Our ref: DOC20/870961

Senders ref: SSD-7874

**Subject: EES comments on Response to Submissions and further amended Concept Plan for Harbourside Shopping Centre – SSD-7874 – Darling Harbour**

- Response to Submissions and Further amended Concept Plan (RtS) – 12 October 2020
- Appendix H – Landscape Design Report (LDR) – October 2020

1 DEMOLITION PLAN
3000-00 1:500

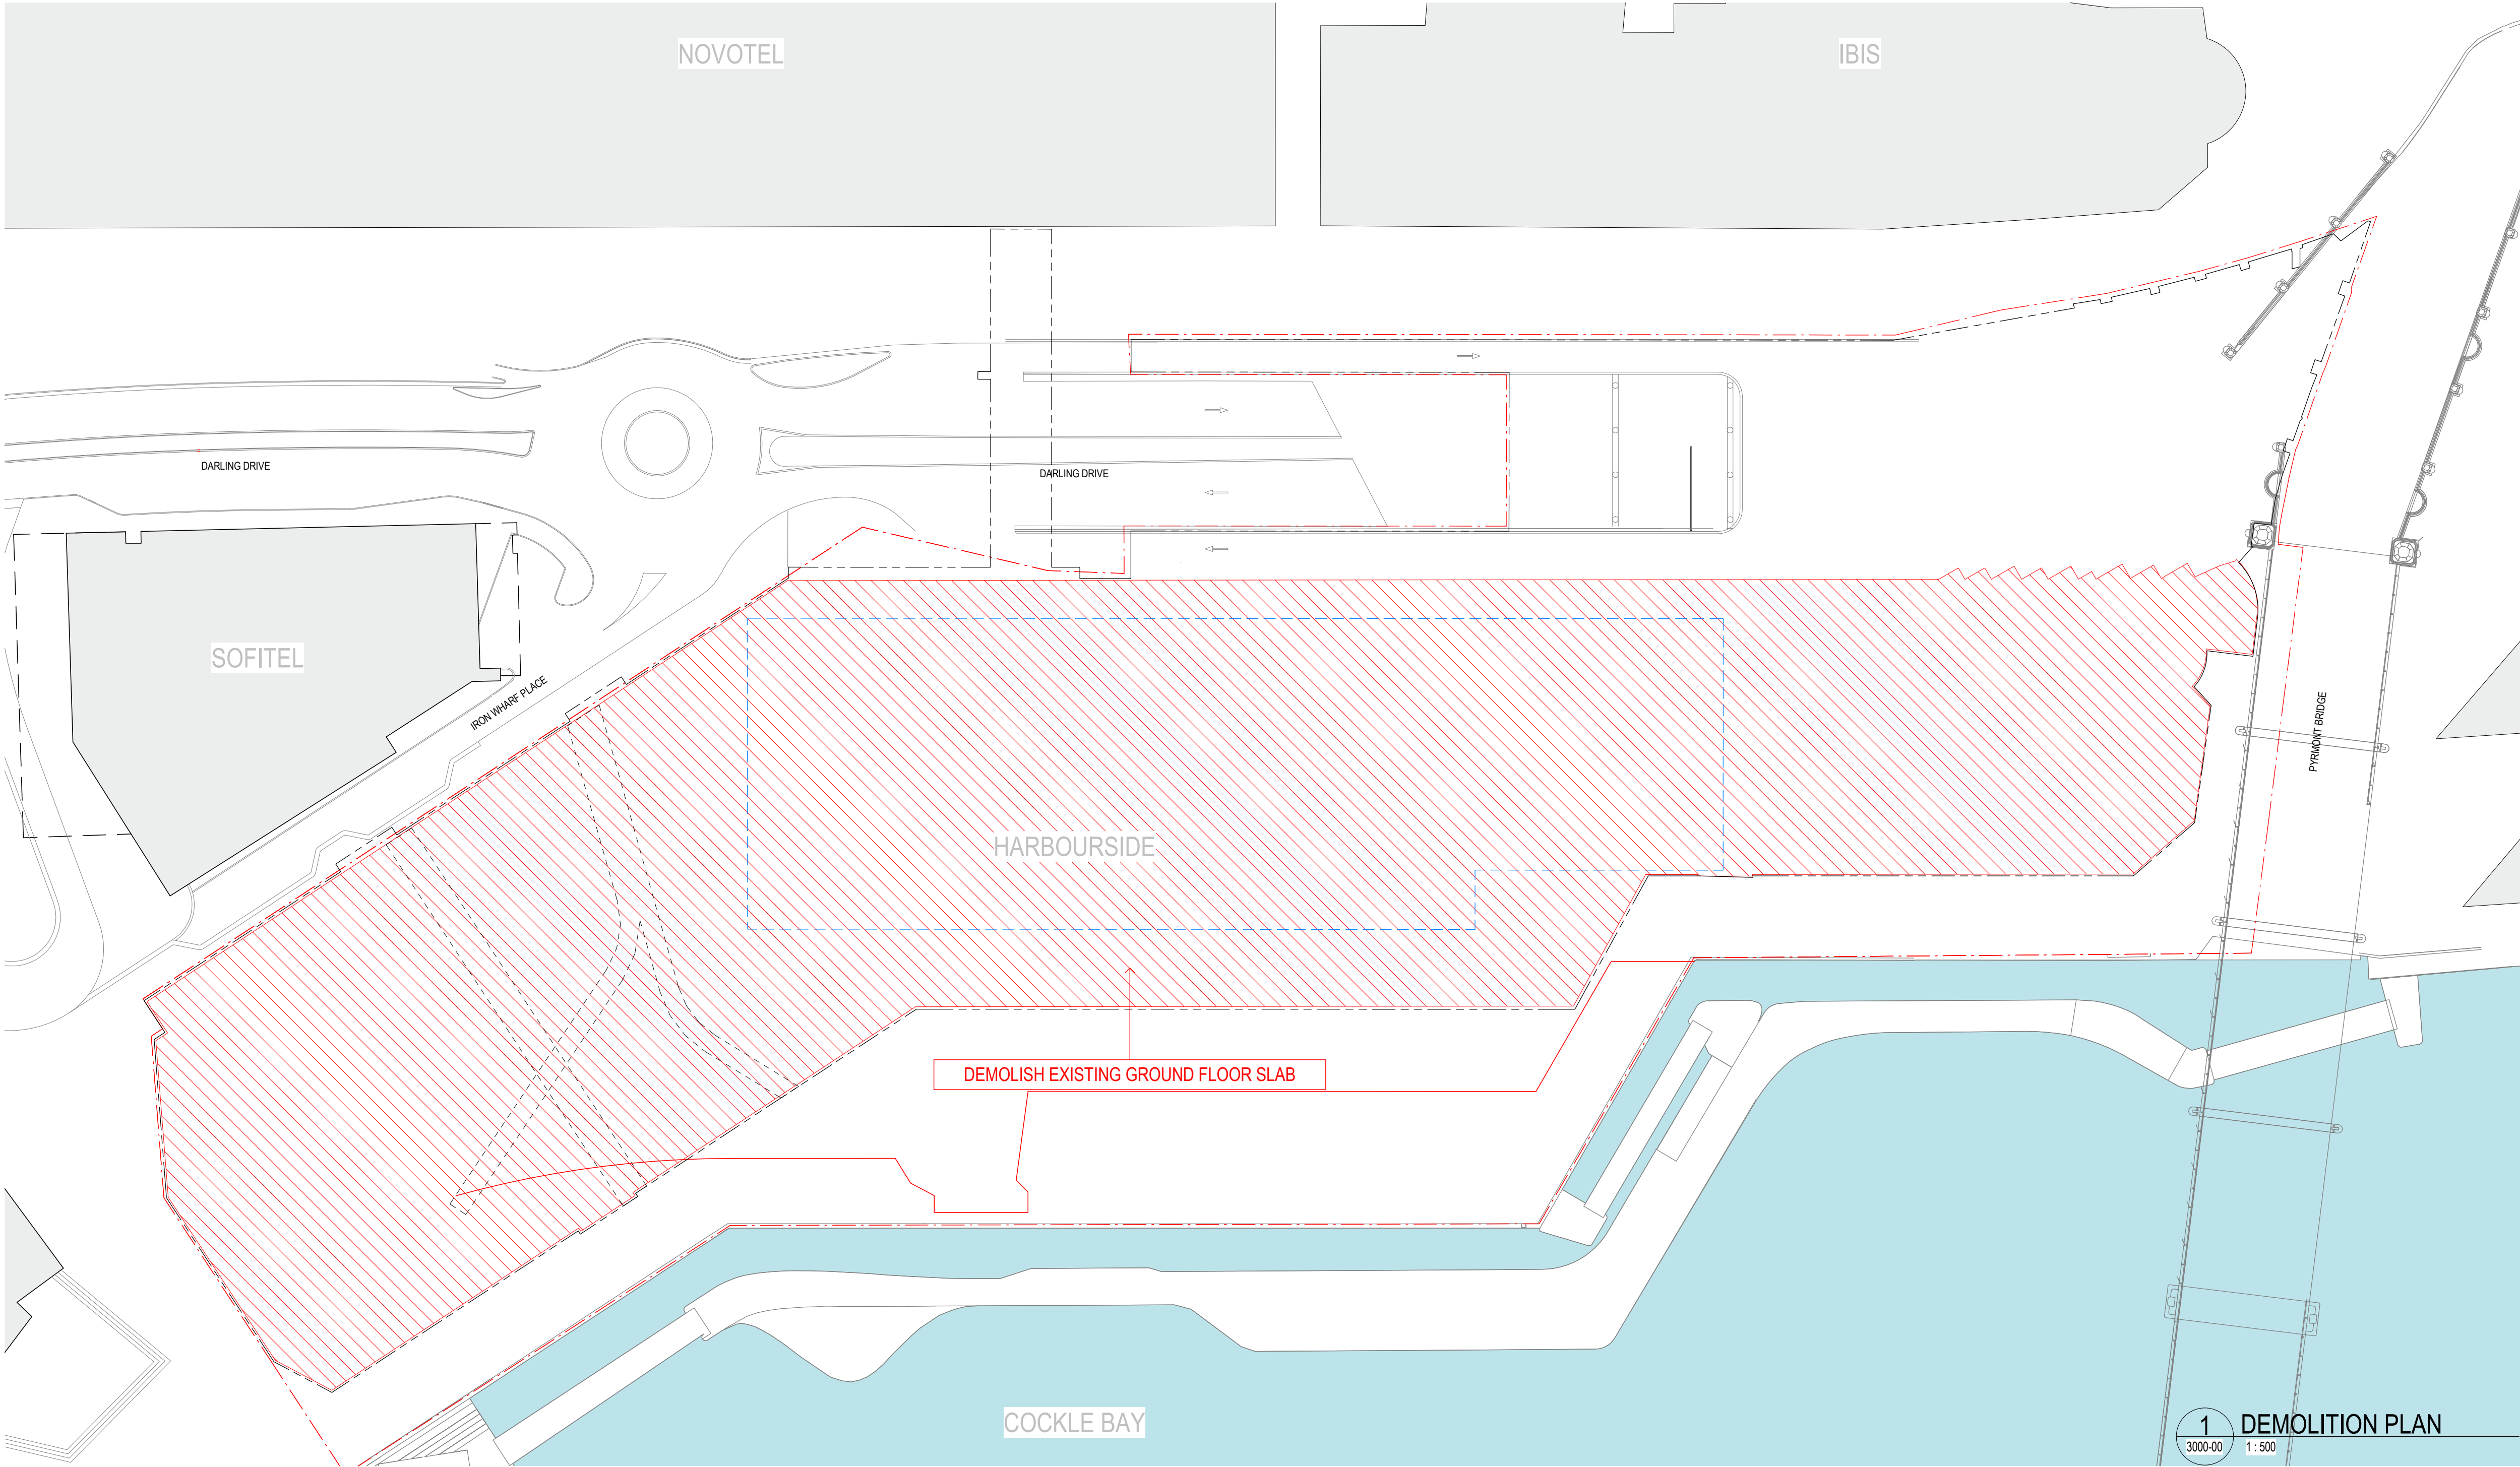
EES notes previously, no physical works were proposed as part of the concept DA and demolition was to be subject to a future Demolition DA following the approval of the concept application. However, approval is now sought for Stage 1 demolition works (physical works) involving the demolition of existing site improvements, inclusive of the Harbourside Shopping Centre, existing Monorail station, and existing pedestrian bridge over Darling Drive and associated tree removal down to ground slab level (no ground disturbance) as part of the concept DA approval process (sections 3.5.8 and 4.2 of 61 of RtS).

The amended Concept Plan has not considered the presence and possible value of habitats afforded by the existing artificial/built structures, for example the existing building and pedestrian bridge. Several microchiropteran bat species, some threatened, are capable of roosting in a variety of natural and constructed sites, so it is possible that they might utilise the existing built features on this site.

Information is required to confirm the absence of roosting habitat for threatened microbats within the existing buildings. A search for evidence of microbat roosts should be undertaken using appropriate methods, such as those described on page 9 of the '*Species credit' threatened bats and their habitats NSW survey guide for the Biodiversity Assessment Method* (OEH 2018).

Pre-clearing surveys should apply to any buildings or structures with potential roosting habitat that are to be demolished and such surveys should be carried out by a suitably qualified and experienced microbat specialist and if microbats are present, then works should not be carried out when they are likely to be in torpor.

The Boulevard

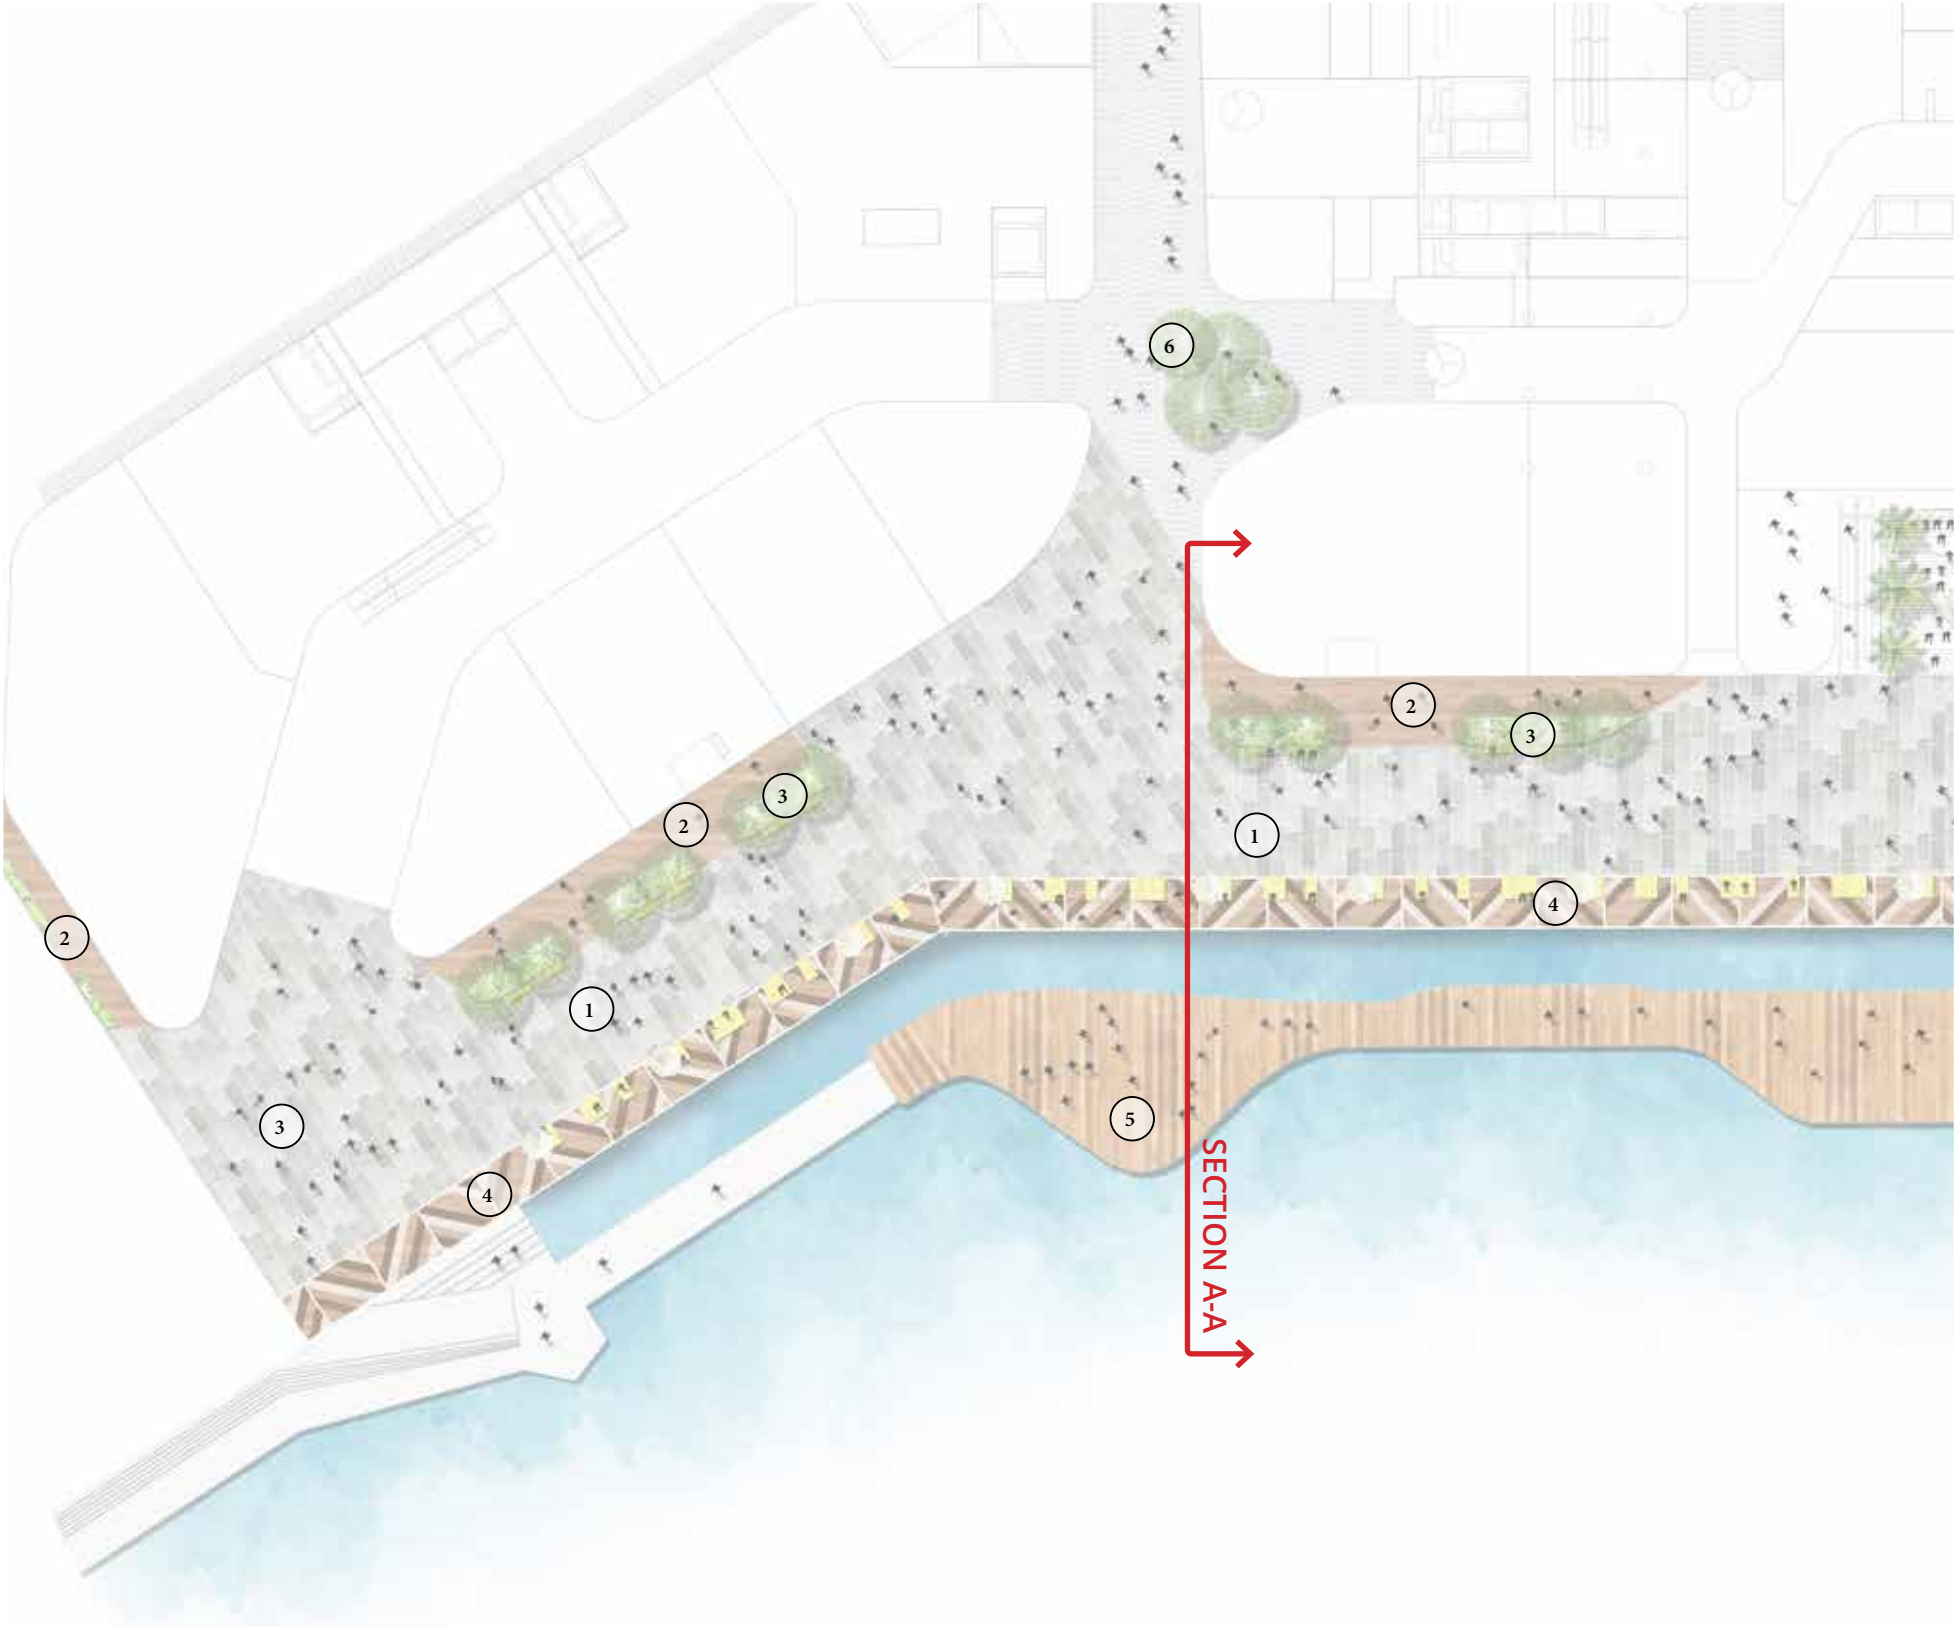
The LDR notes the amended proposal includes the planting of trees within the public domain, between the building and foreshore (page 14). It states, "the Boulevard will be widened and provide a continuous canopy of trees along the waterfront providing shade and habitat" and it indicates the proponent has worked hard to align the concept proposals with the design objectives outlined in the Draft Pyrmont Place Strategy. EES notes an objective of this strategy is to provide a

contiguous harbour foreshore parkland (page 25) but EES questions whether the Boulevard provides a contiguous harbour foreshore parkland.

The SSD should not reduce the existing width of the waterfront area. The SSD provides a great opportunity to increase the width. The width should be as wide as possible to accommodate the planting and growth of native trees to maturity.

Level 4 - Landscape Plan

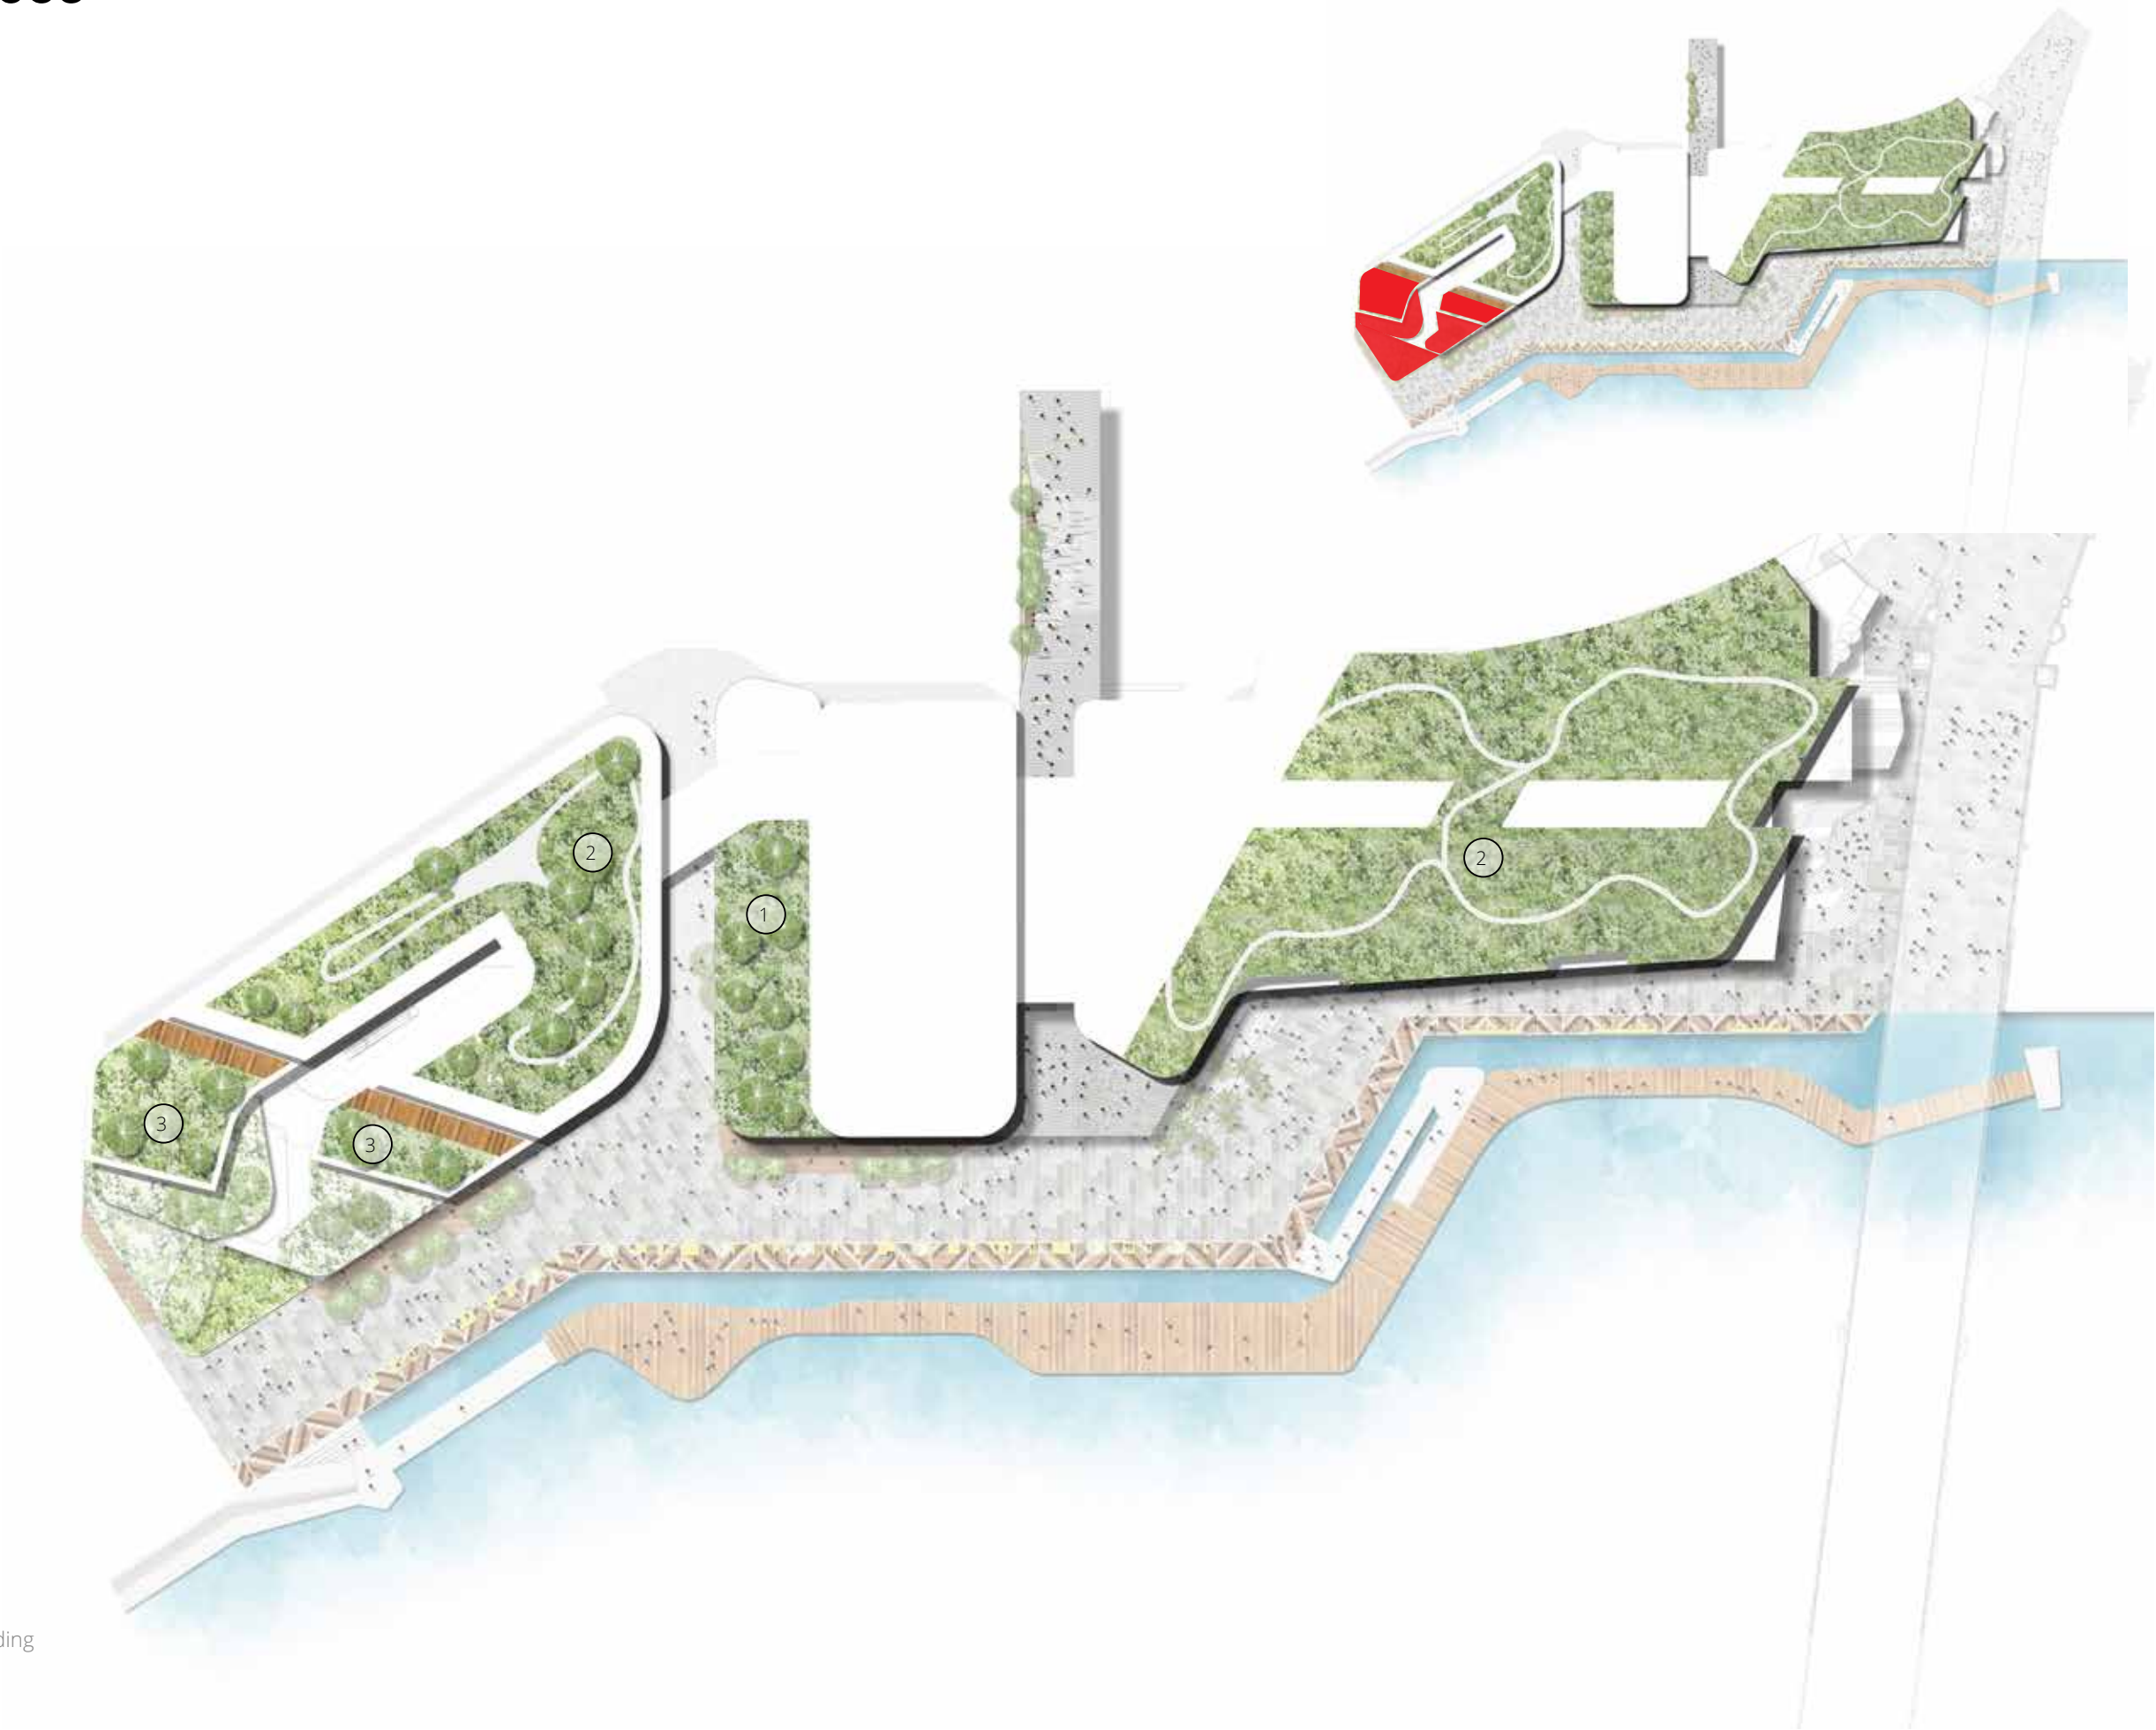
The RtS indicates the current design maximises the green roof opportunity and the proposal has been revised to provide a more extensive and diverse mix of local native plant species for improving biodiversity and habitat value of the green roof (page 26). EES supports the provision of the green roofs but recommends the planting consists of a diversity of local native provenance species that once occurred in this locality.
